Application for Approval of Details Reserved by Condition

Air source heat pump –

Drawing Title:
Revised ASHP east
elevation – Willow Hurdle

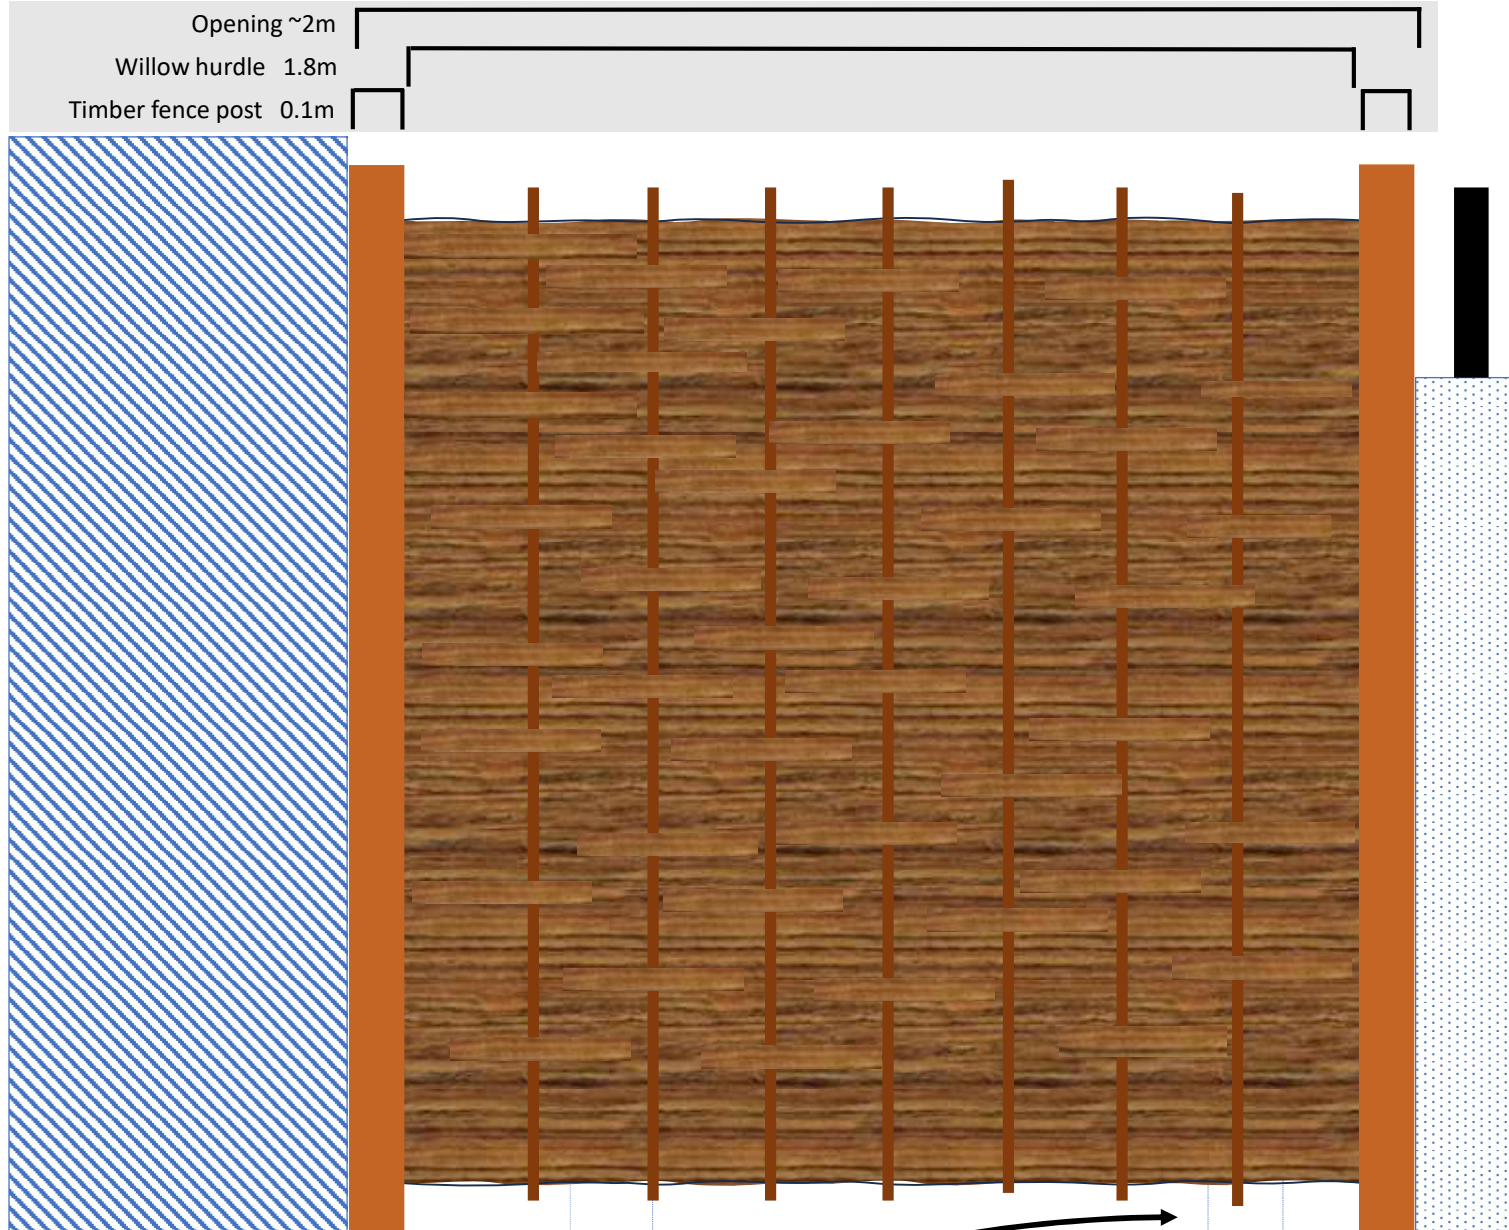
“ It is suggested a more natural screen is used, such as a willow fence panel. Can the distance between the end of the screening and the wall also please be indicated in future applications as this should be a minimum size to reduce visibility of the ASHP.”
